Response to the Examining Authority's Rule 17 Questions

**for the
Royal Society for the Protection of Birds**

**Application by Alternative Use Boston Projects Limited for an
Order Granting Development Consent for the
Boston Alternative Energy Facility**

Planning Inspectorate Ref: EN010095

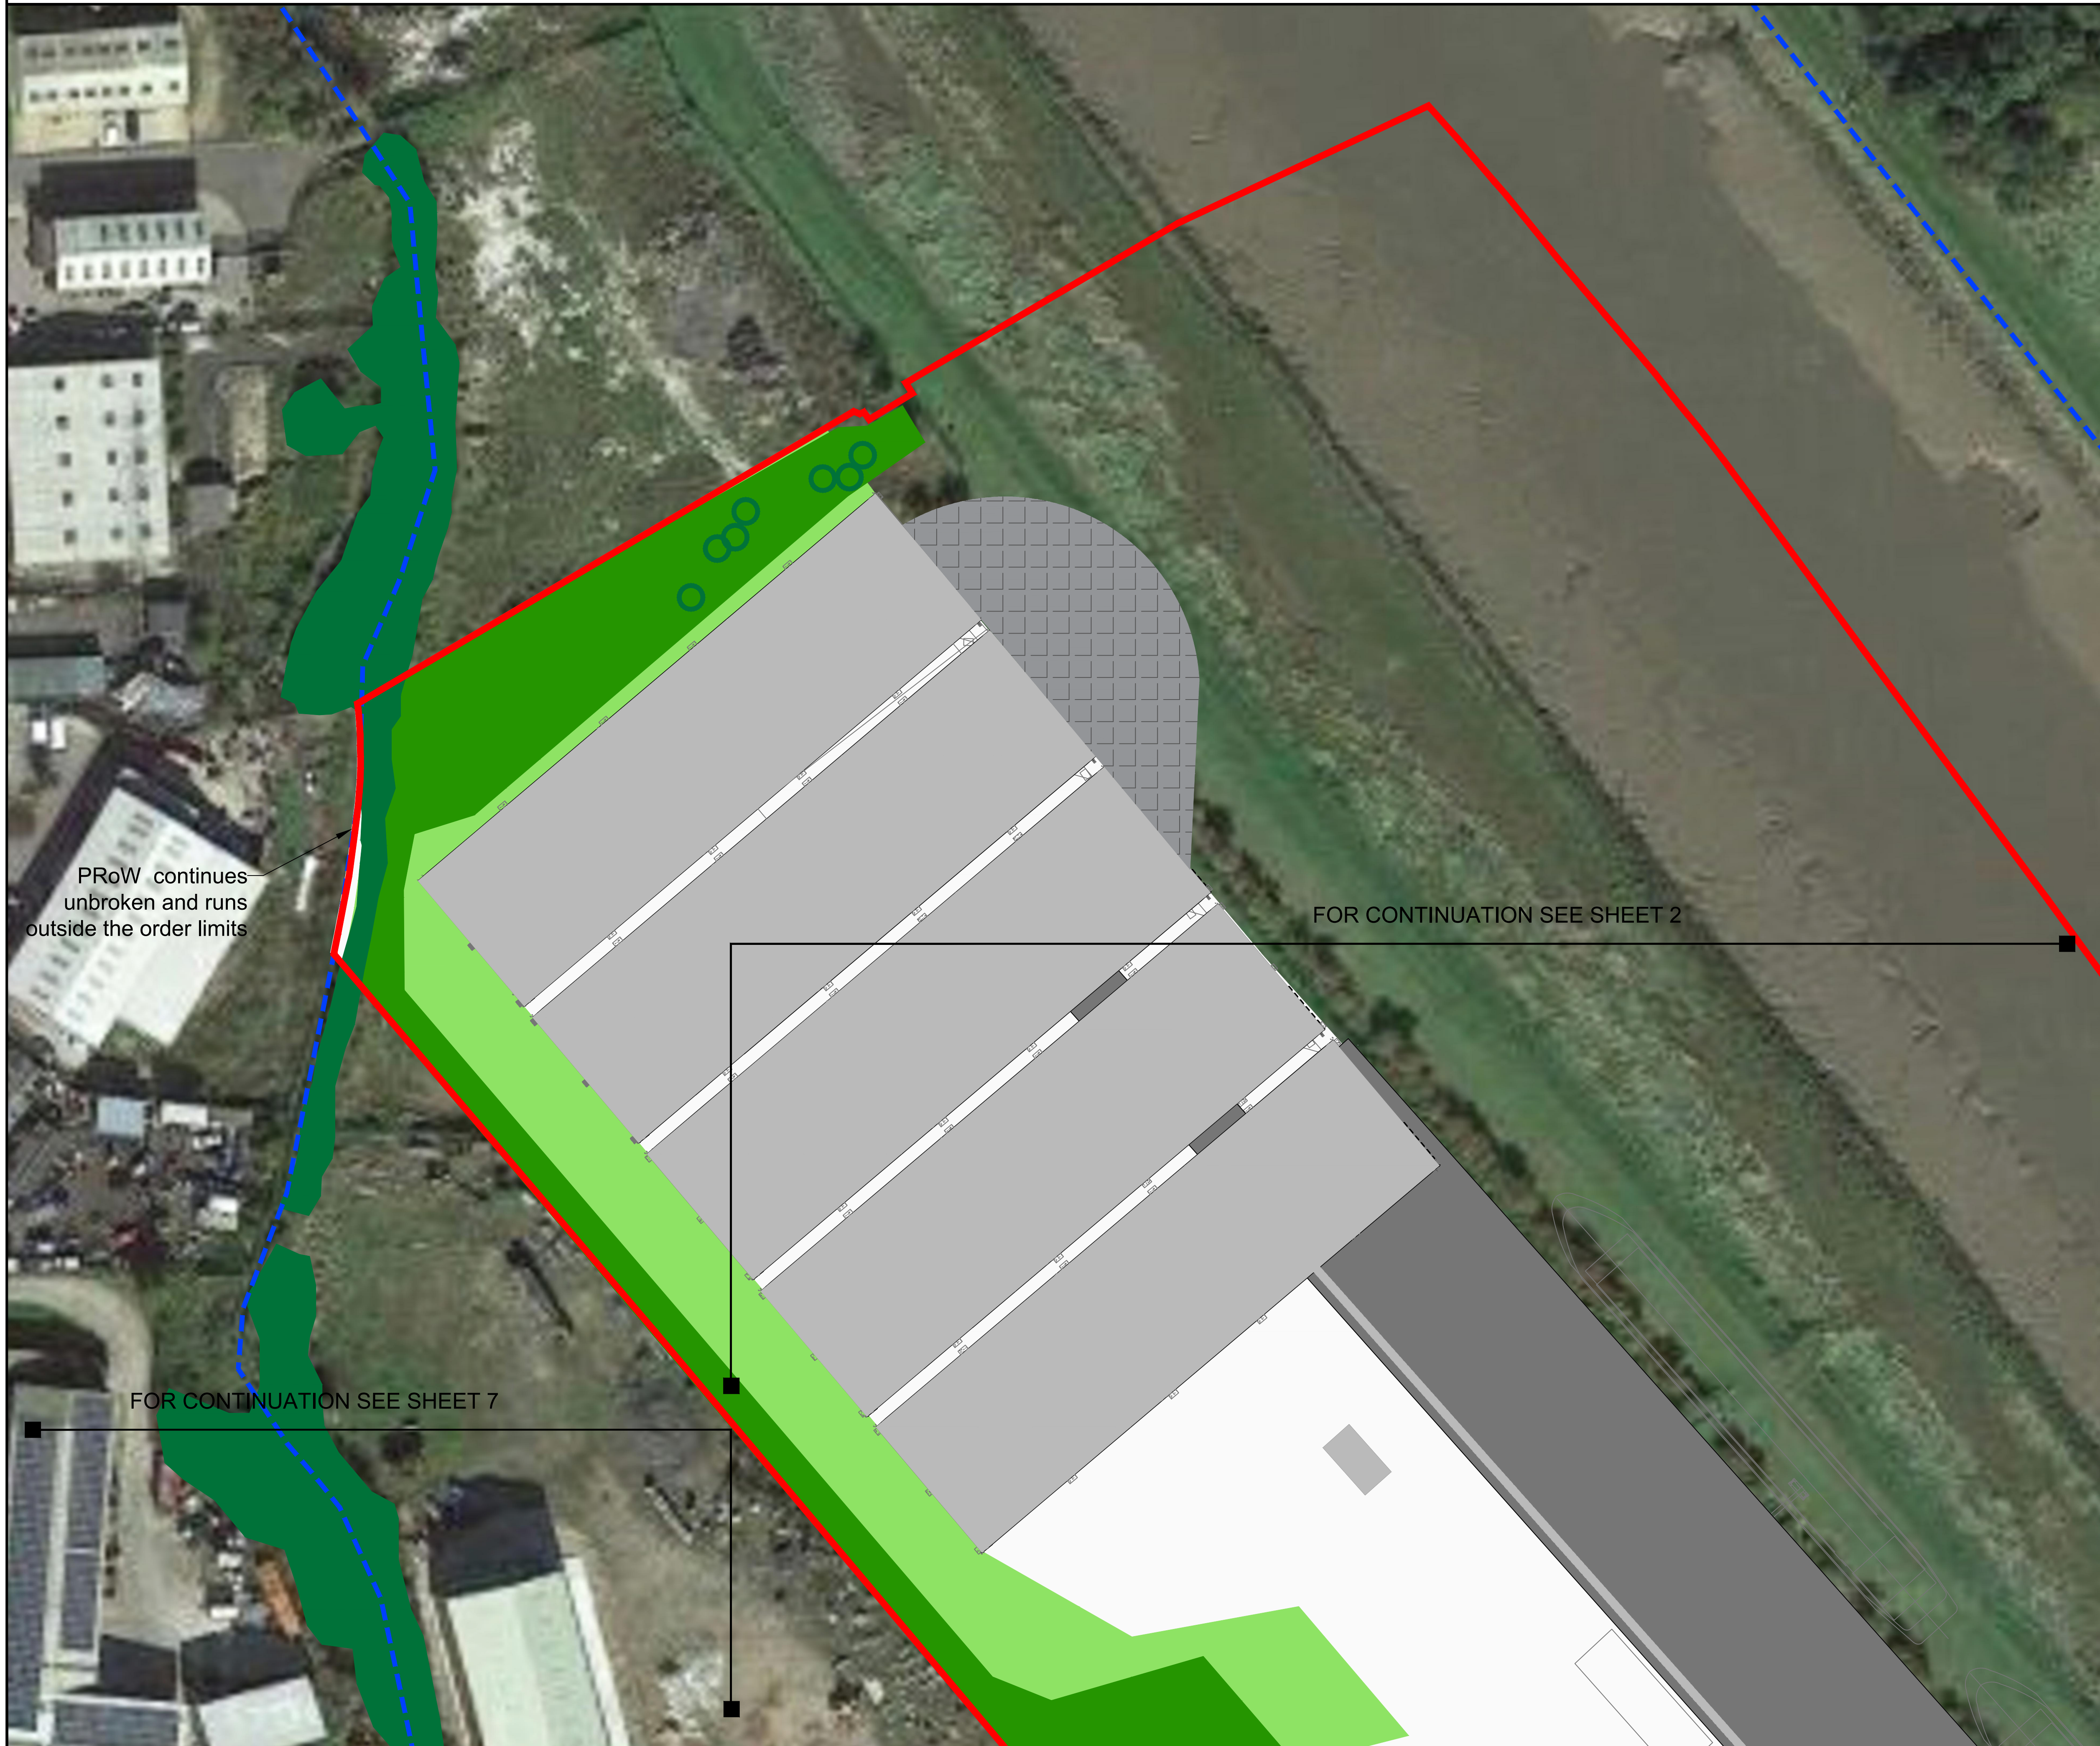
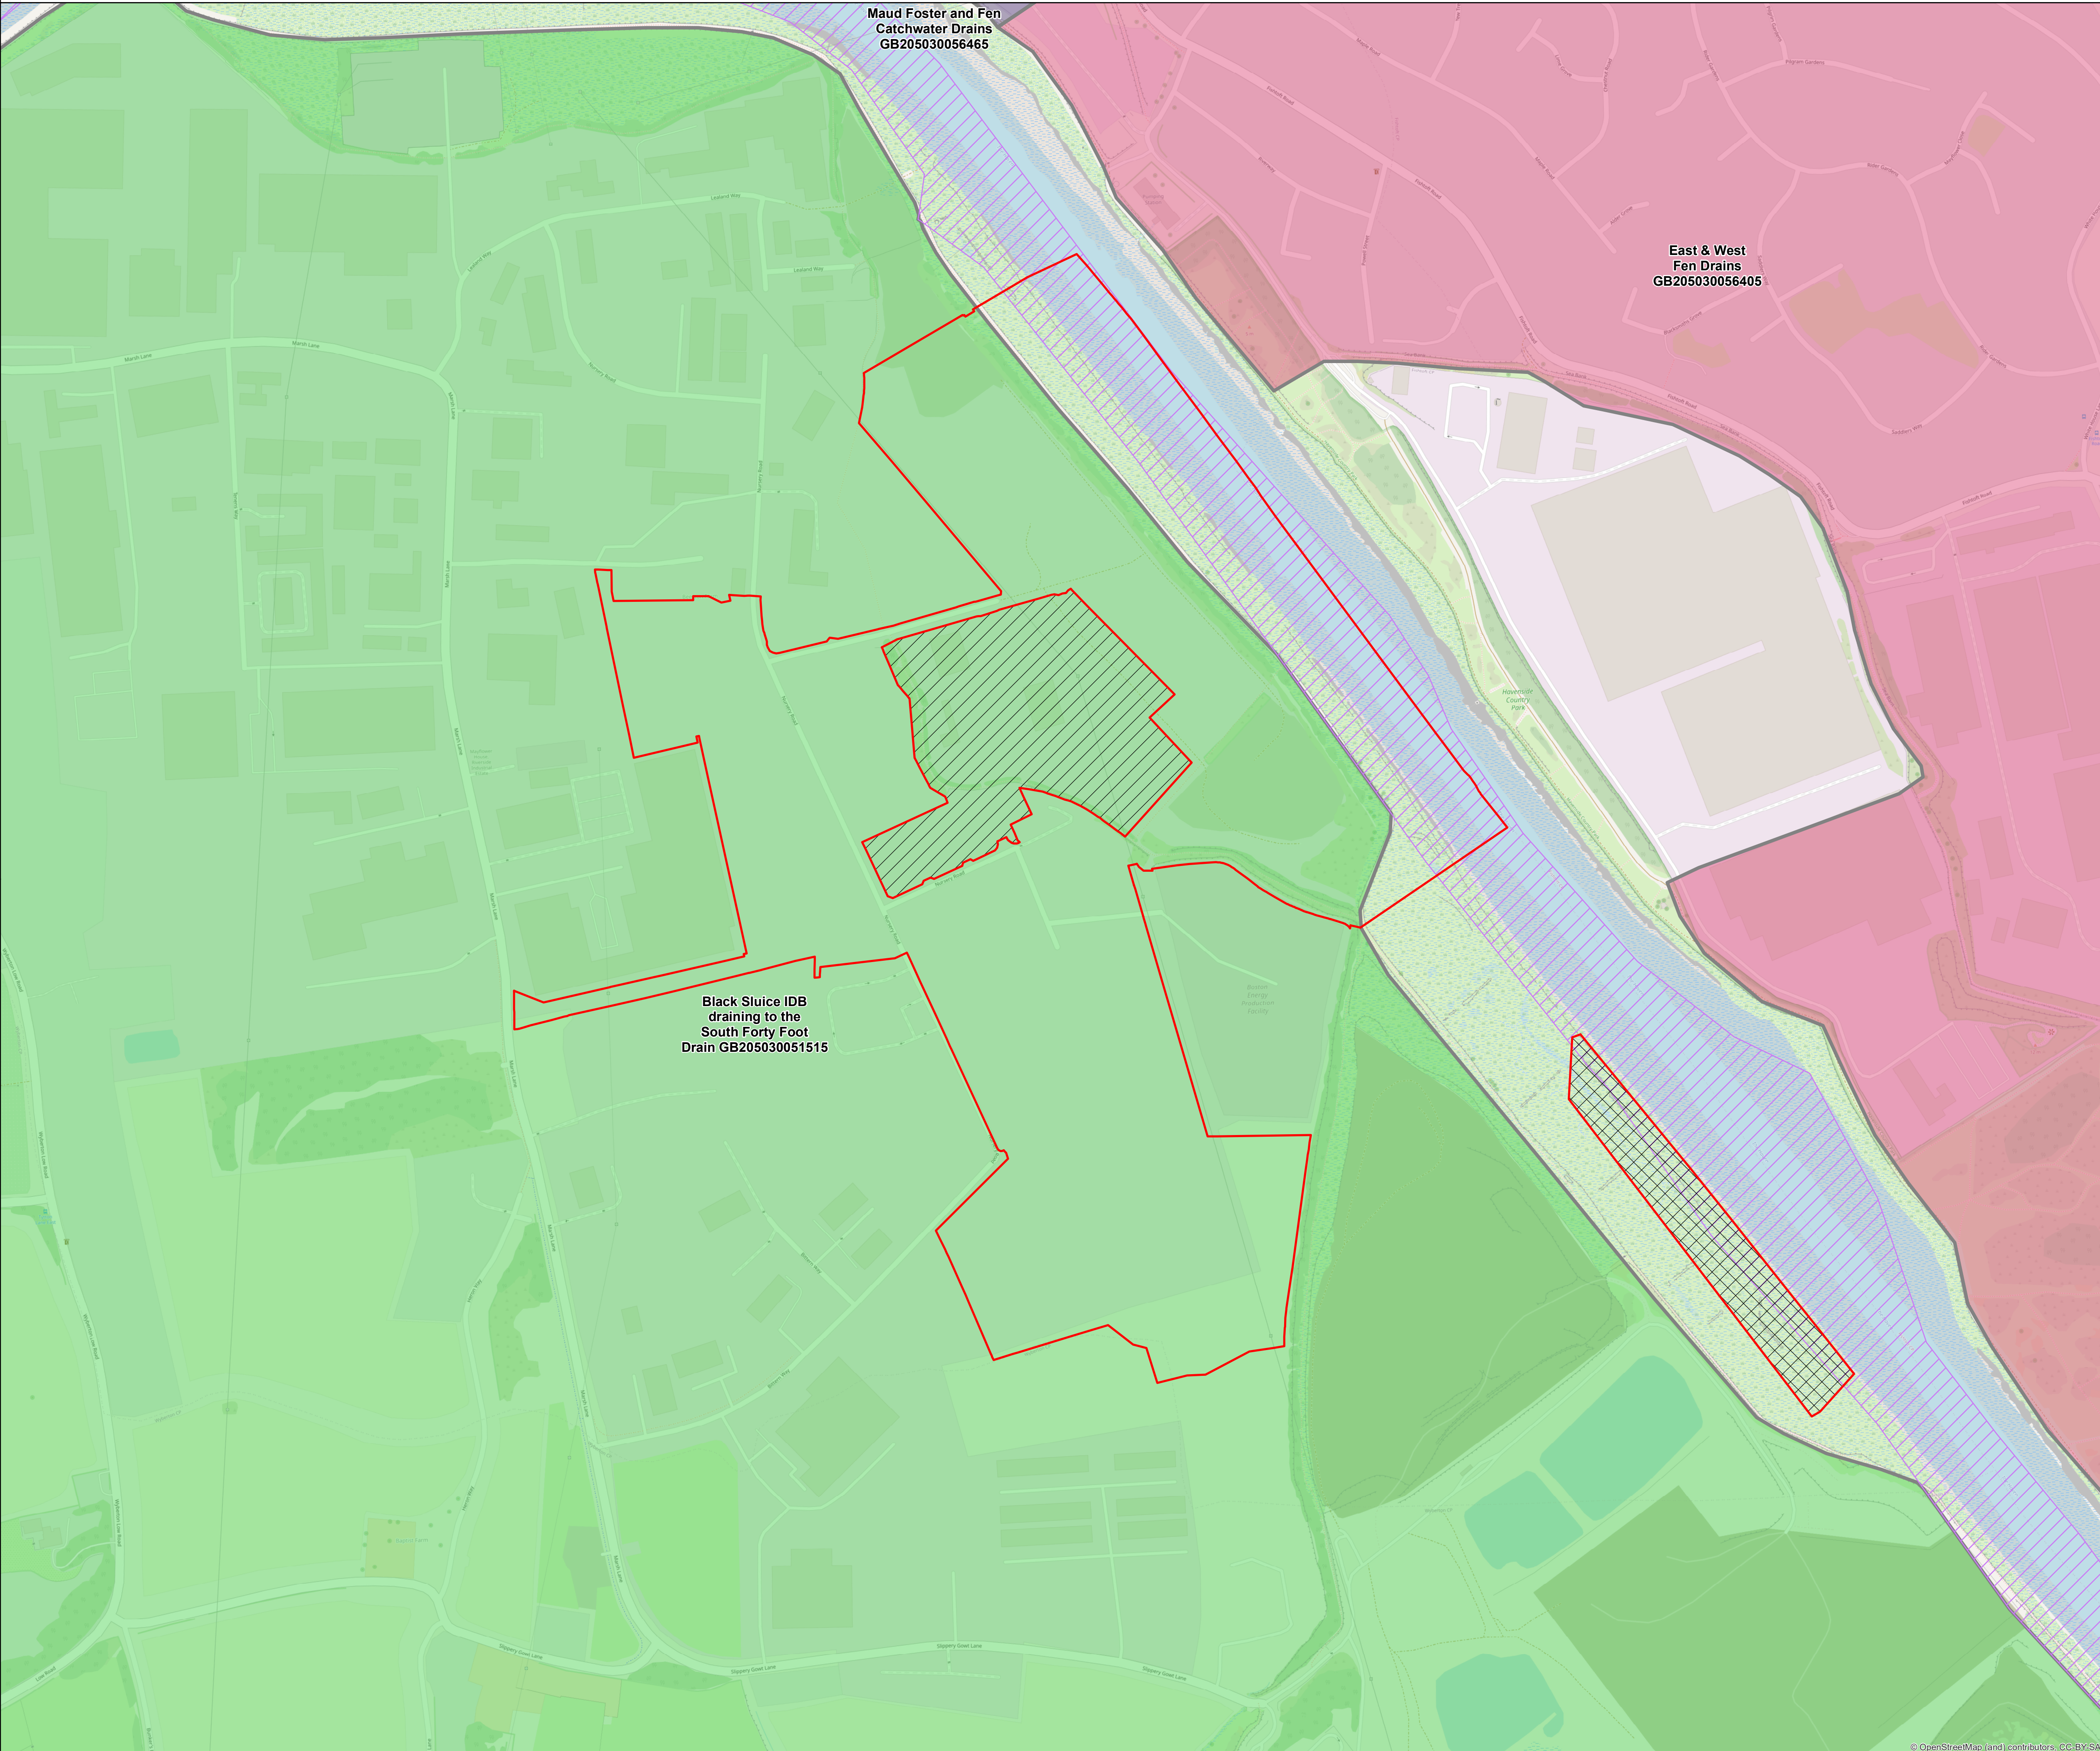
NE	<p>It is unclear from differing comments in documents submitted at Deadline 9 whether NE consider the Habitat Mitigation Area to comprise a mitigation or compensation measure [REP9-063 and REP9-058]. Please confirm the position.</p>	<p>To confirm, the RSPB considers the 'Habitat Mitigation Area' could deliver suitable habitat to address the lost roosting at the wharf site. However, there remain significant uncertainties about its ability to be effective as mitigation given its location close to the Application site and the influence of vessel traffic on the site. There are also no measures proposed to address any recreational pressures that have the potential to affect the sites effectiveness. It will also not address the full loss of foraging habitat. Consequently, we consider the replacement roost and foraging habitat must be considered as compensation and delivered at a location where there can be more certainty that effective roosting and foraging for waterbirds, notably redshanks and ruffs, will be delivered.</p> <p>We also note that paragraph 6.10 (p.44) of the CIEEM 'Guidelines for Ecological Impact Assessment in the UK and Ireland: Terrestrial, Freshwater, Coastal and</p>

Question addressed to	ExA question	RSPB comments
		<p>Marine Version⁶ provides a useful summary of what constitutes mitigation and what constitutes compensation:</p> <p><i>“The distinction between mitigation and compensation can be difficult to determine. Where ecological equivalence can be delivered within the project site this is sometimes incorrectly considered mitigation rather than compensation. However, the correct distinction between mitigation and compensation is that mitigation avoids or reduces the occurrence of negative impacts and effects and compensation addresses effects which are residual, after avoidance and mitigation have been considered. Measures to address impacts and effects that will occur should therefore be referred to as compensation whether the compensation is located within or outside of the project site.”</i></p> <p>Based on the above definition set out in the best practice guidance, we consider this supports our position that the proposed ‘Habitat Mitigation Area’ should best be considered compensation. This would require commensurate changes to the draft DCO/DML and contents of the draft Ornithology Compensation Plan.</p>
